**Re: Request advice on the RTS for SSD-58978472 – Kelso Crescent Multi-Level Warehouse, Moorebank**

## Attachment A – Detailed comments

### 1. Urban Design

Appendix D Arboricultural Impact Assessment Report Tree Map and Tree Schedule

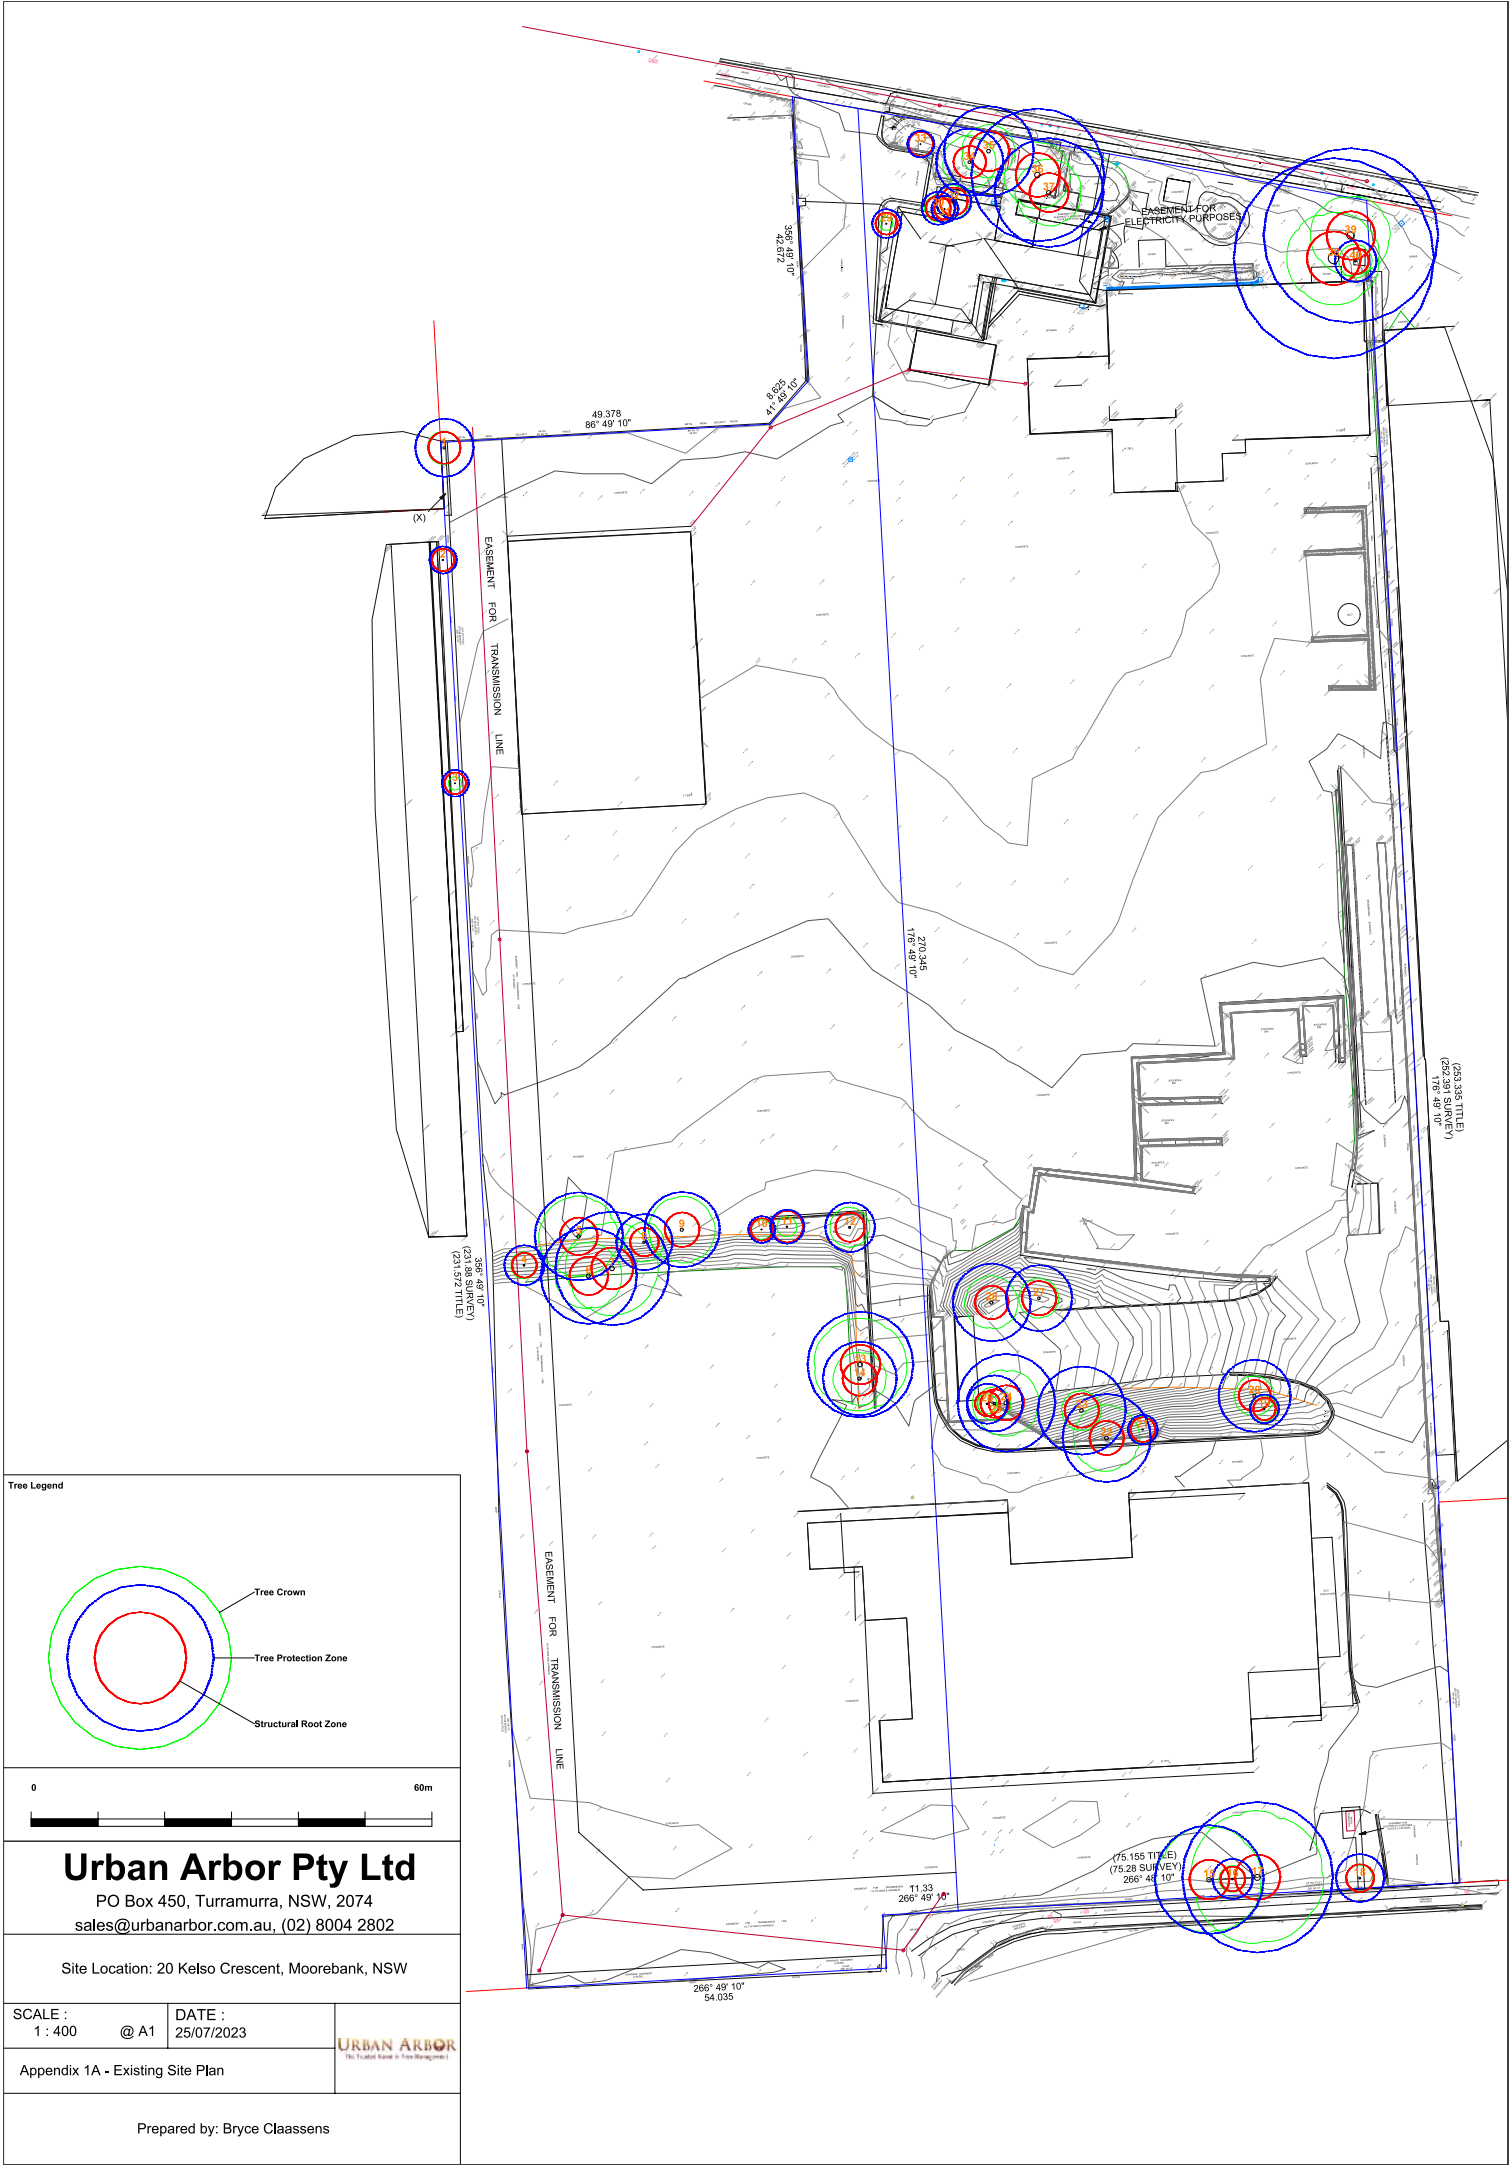
<p><b>Tree Retention</b></p> <p><i>Several native, mature trees in good condition and within the front landscape setback and proposed to be removed (being: T15, T16, T17, T36 and T37), and this is not supported. Pot sizes should therefore be increased for several of the trees to a minimum 100L, and 200L for street trees, to reduce the time it will take for canopy to establish</i></p>	<p><b>Not addressed</b></p> <p>These trees are all native, mature trees, all in at minimum good condition except for T16 which is 'fair' condition.</p> <p>T36 – the pedestrian entry could be reconfigured to keep.</p>

<div data-bbox="815 170 1398 689"></div> <p data-bbox="815 768 1398 831">Unclear why T15, T17 cannot be retained as well, now that T16 is being retained.</p> <div data-bbox="815 853 1141 1189"></div> <p data-bbox="815 1267 1398 1330">The Arborist report just states 'Remove' against these trees with no justification why.</p> <p data-bbox="815 1408 1398 1471">Street trees have not been shown, these should be shown and pot sizes at 200L.</p>
<p data-bbox="193 1552 802 1583"><b>Safety and Amenity</b></p> <p data-bbox="193 1606 802 1944"><i>The Kelso Crescent car park entry is very close to the main pedestrian entry. Council recommends the applicant increases the separation between both entries to improve safety for pedestrians. Council is supportive of the external terrace to the office space, however, seeks clarity as to whether it is accessible to all staff or just those working in the adjacent office. The applicant should demonstrate that all staff</i></p>	<p data-bbox="815 1606 1398 1637">Not addressed.</p> <p data-bbox="815 1715 1398 1778">The car park and entries are not separated by 8m landscaped as described.</p> <p data-bbox="815 1856 1398 1919">The distance/dimension in question is illustrated below and appears to be 2-3m.</p>

1 .ROOF PLAN
1 : 500

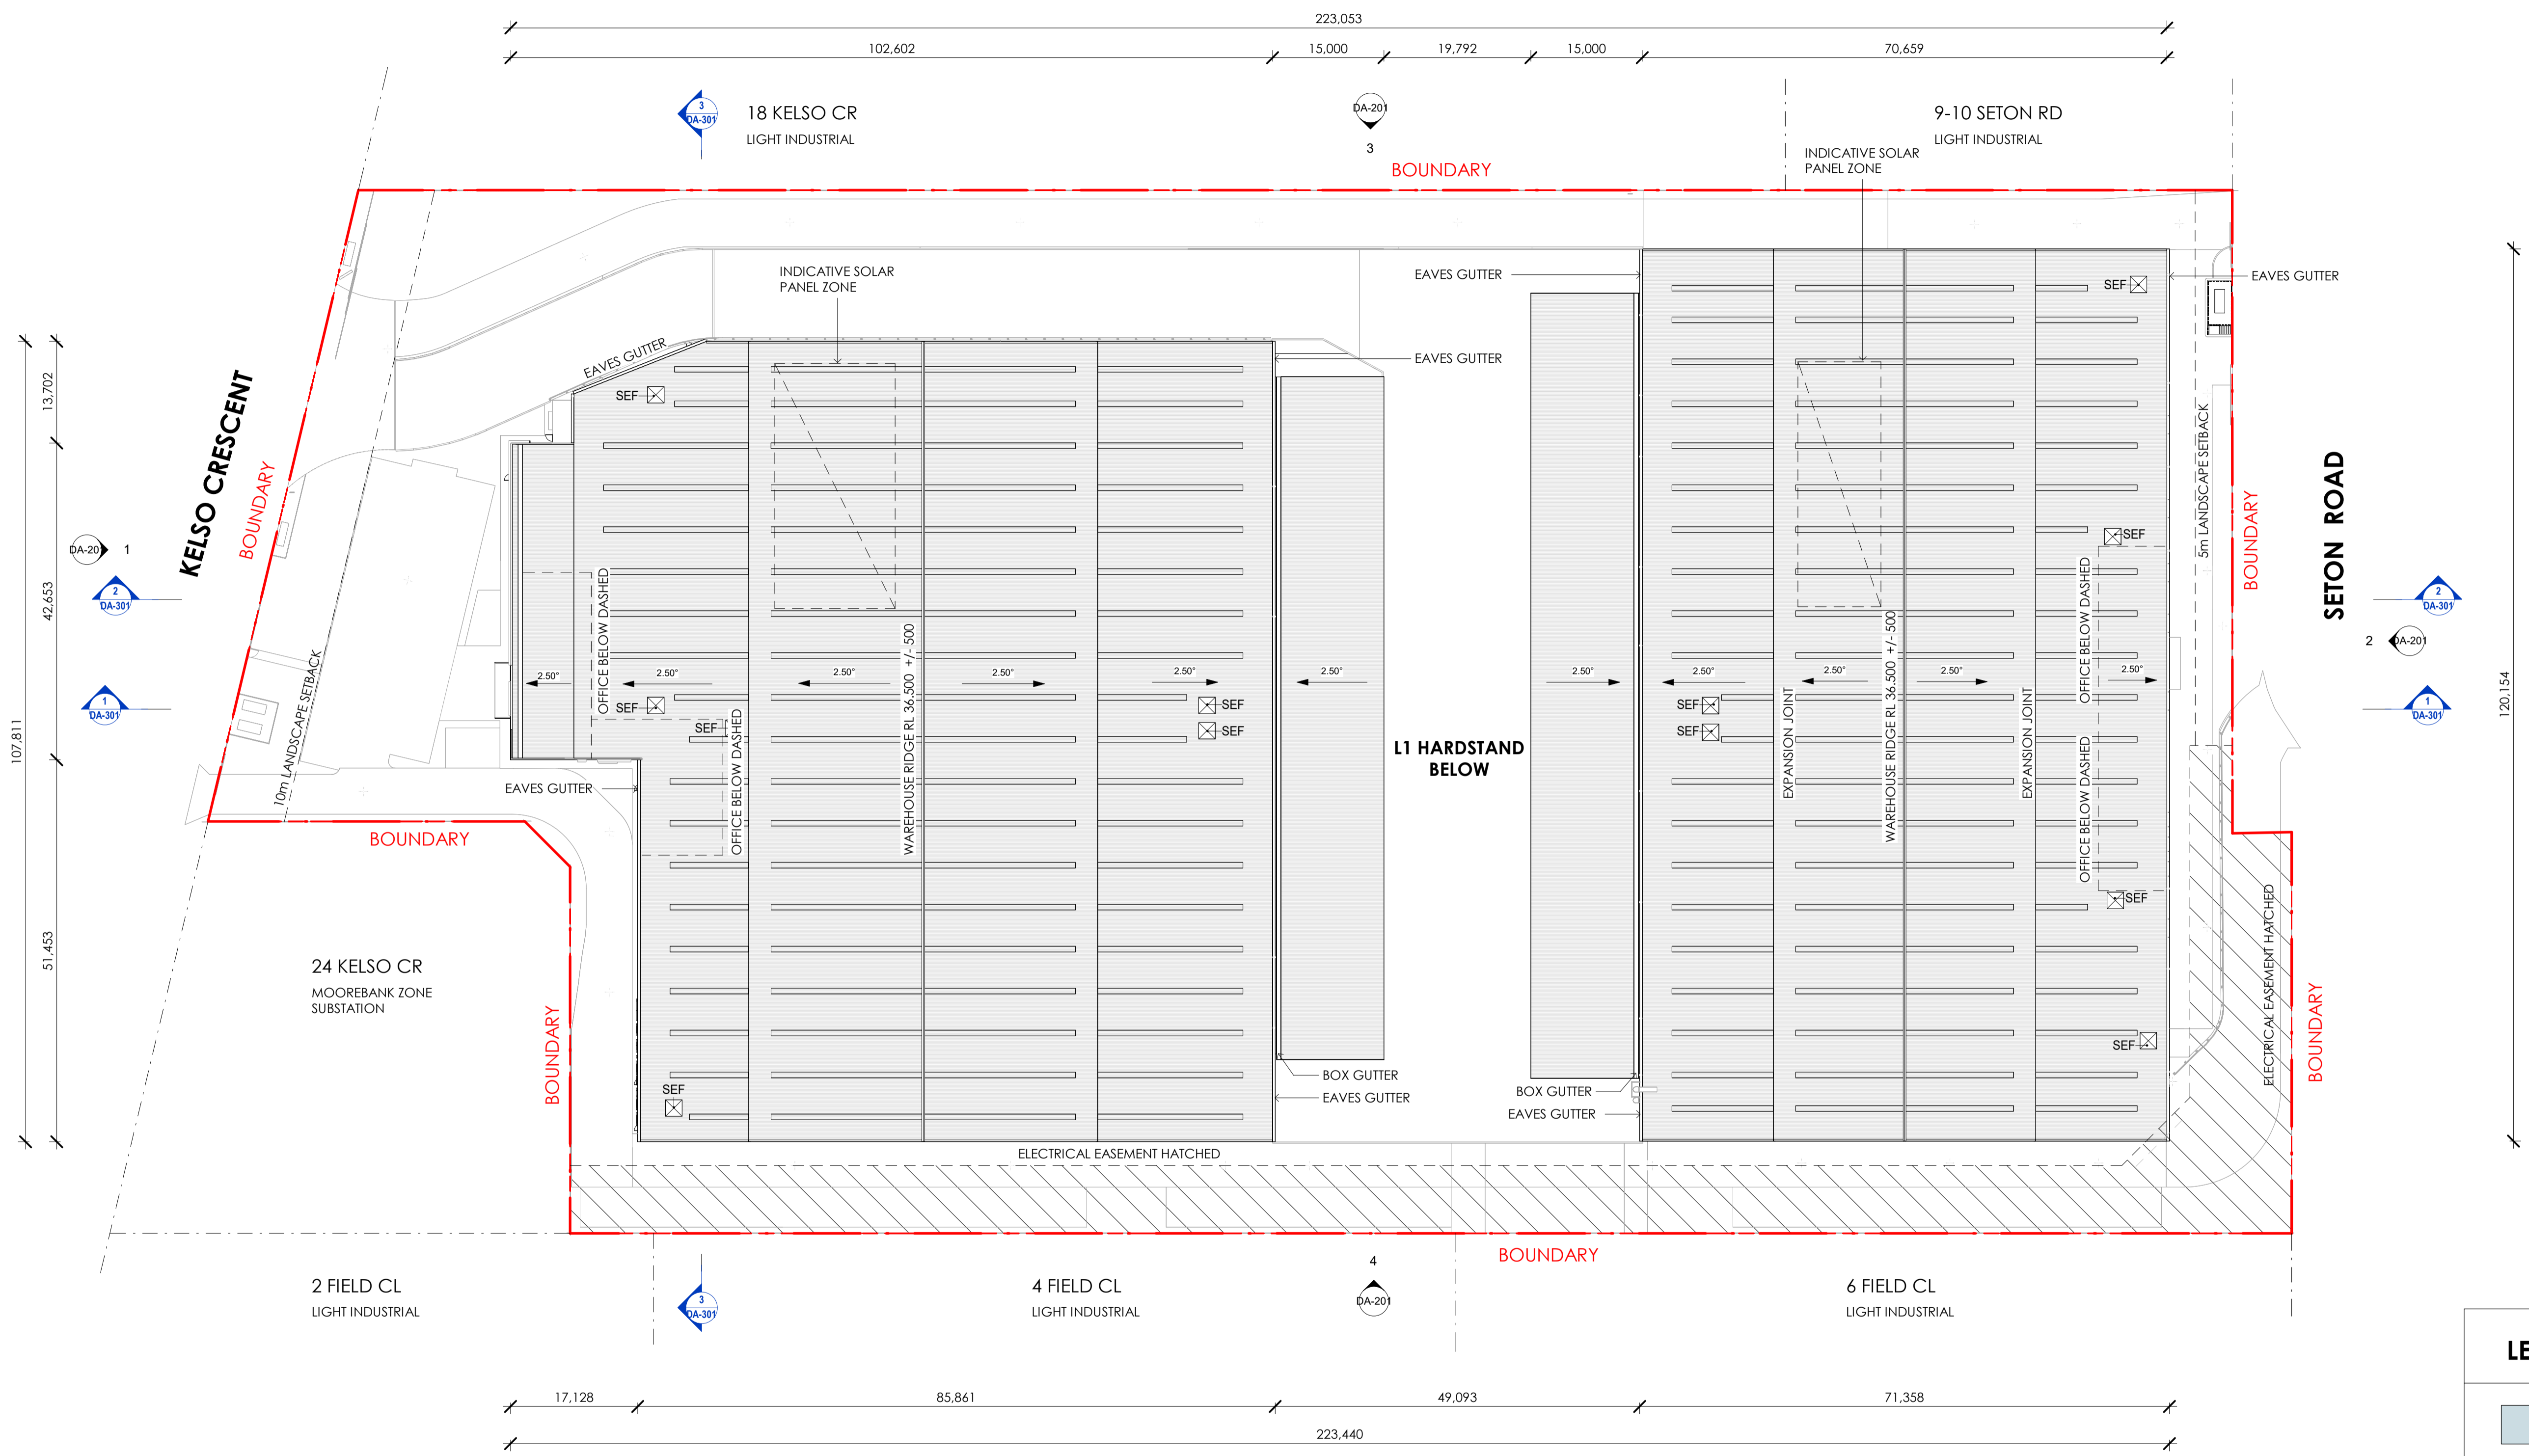
<p><b>Sustainability</b></p> <p><i>The design of the separate emergency vehicle access driveway results in a considerable amount of concrete surface area that will rarely be used and will greatly contribute to the Urban Heat Island. Council staff encourage the applicant investigate innovative strategies surrounding design and materiality of the driveway, to enable emergency vehicle requirements to be met whilst still minimising impact to the environment, (i.e. permeable materials, with less heat absorption). Council staff strongly encourages the applicant commit to a number of solar panels and utilise as much of the roof space as possible</i></p>	<p><b>Not addressed</b></p> <p>Paving - Urban Design emphasises the importance of this recommendation and encourages greater investigation into permeable paving products that are designed for heavy industrial traffic and road infrastructure.</p> <p>Solar Panels – Not addressed, revised roof plan has not been provided and no justification provided</p>

2 OVERALL SOUTHERN ELEVATION
1: 500 A-204

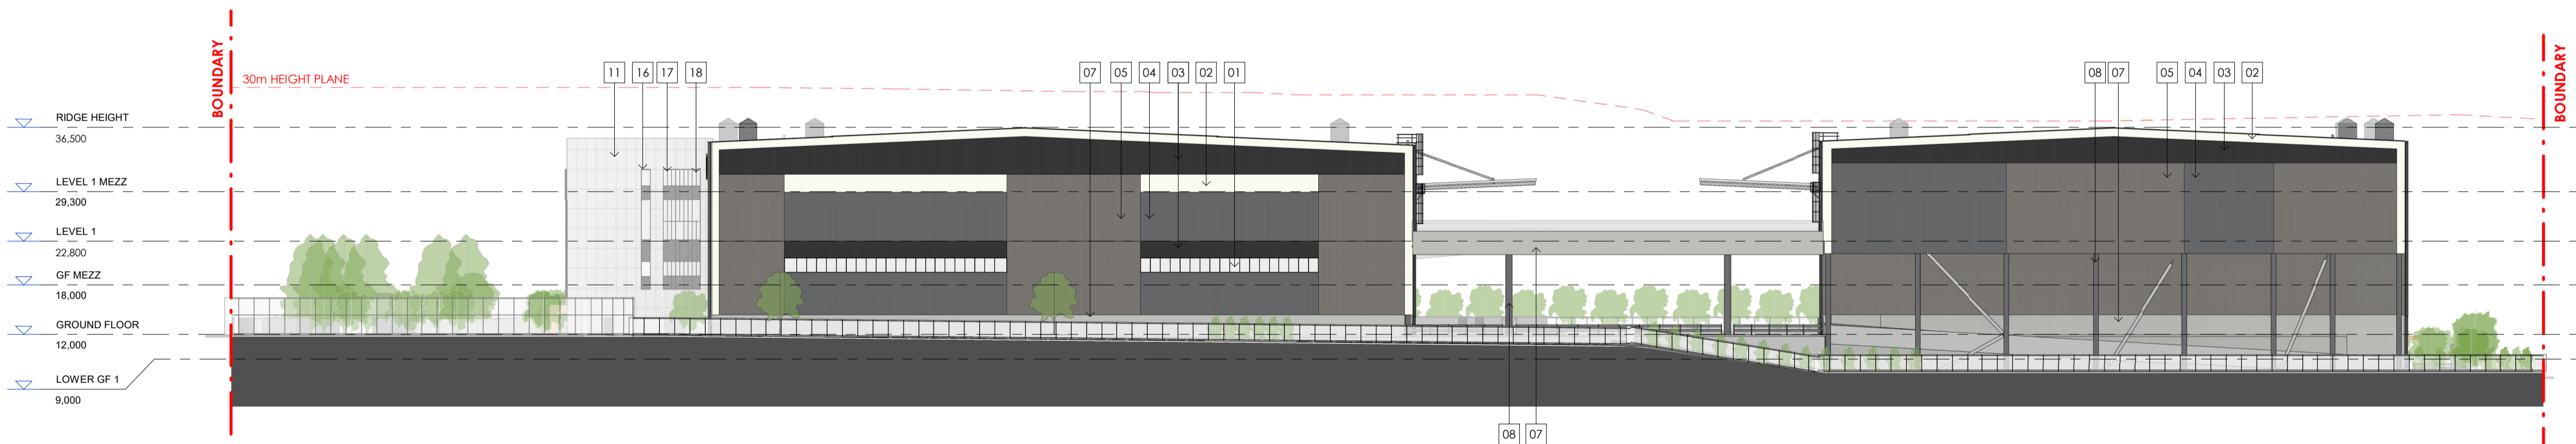
The ground level of the southern elevation on Seton Road is mostly blank wall and not an acceptable street interface. The DCP Part 7 Objectives include to “*ensure the creation of an attractive streetscape character and Control - ‘A development must use architectural elements to articulate facades and minimise large expanses of blank walls.’*” The ground level is critical to the character, pedestrian experience and passive surveillance of the street. Council staff recommends the applicant improve the ground floor façade design, through additional windows, permeability, material differentiation, texture and/or articulation. Continuing the approach of the upper levels to lower levels could also be explored.
